From: Kathryn Welch
Sent: 20 March 2026 14:28
To: [REDACTED]
Subject: Y/10/26/PL Rookery Farm

As discussed, it appears that the proposal has evolved beyond the original intention of simply providing 1 new dwelling. Given the extent of development to the rear, the application should be amended to include the change of use of the agricultural land behind the barn to residential use. I would also suggest that the application does not need to refer to the demolition; instead, a retrospective application for the erection of the number of new dwellings would be more appropriate.

2601_200_PL0
*** PROPOSED DRAWINGS**

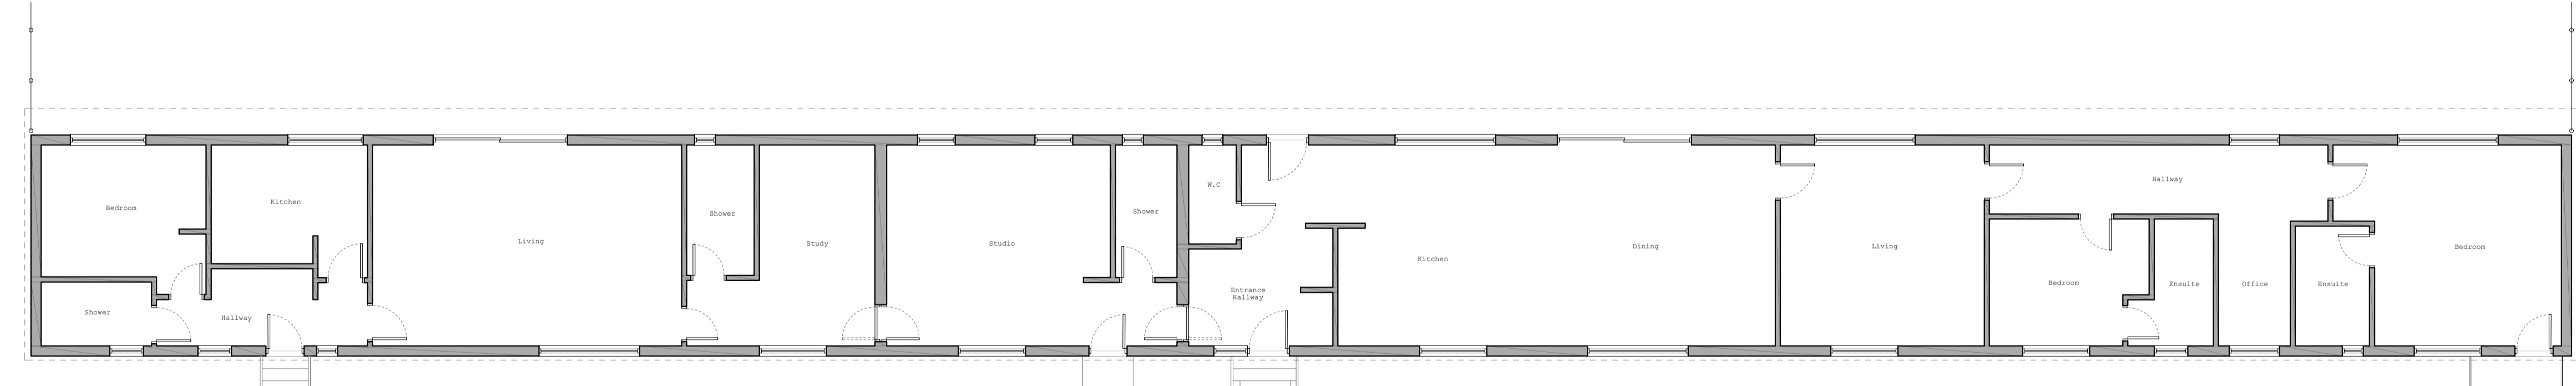
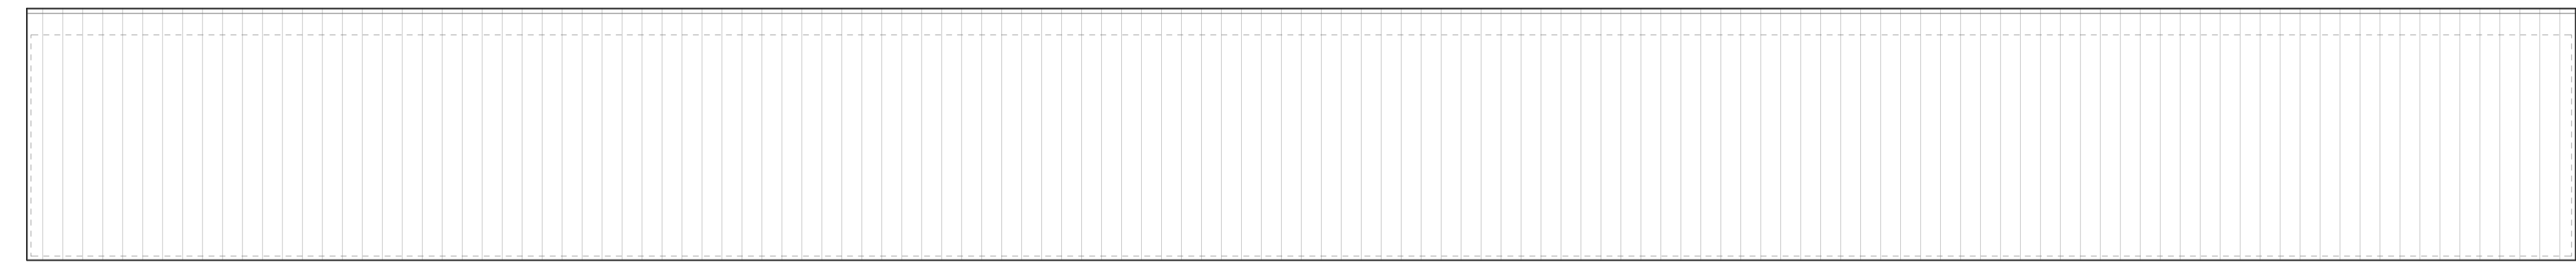
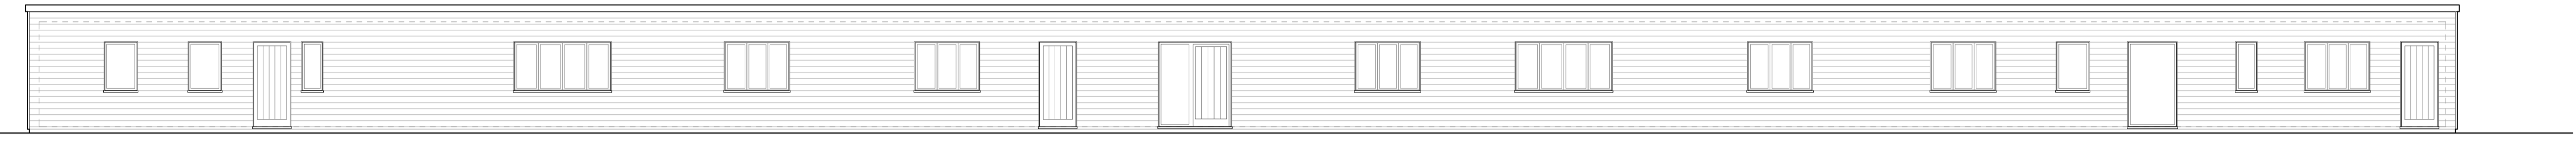
In addition, the plans do not clearly align with a layout comprising one dwelling and one annex. At present, the level of conflicting information renders the application incapable of being approved in its current form.

With regard to the number of dwellings on the site, I consider it evident that; despite the interconnectivity, the building has been designed to function as up to three separate dwellings. Evidence observed on site, including the number of front doors, subdivision of the land, and the number of ASHP units, has informed this view. I have also been provided with a Building Control report which confirms that the structure was designed as three separate dwellings for the purposes of fire-spread regulations.
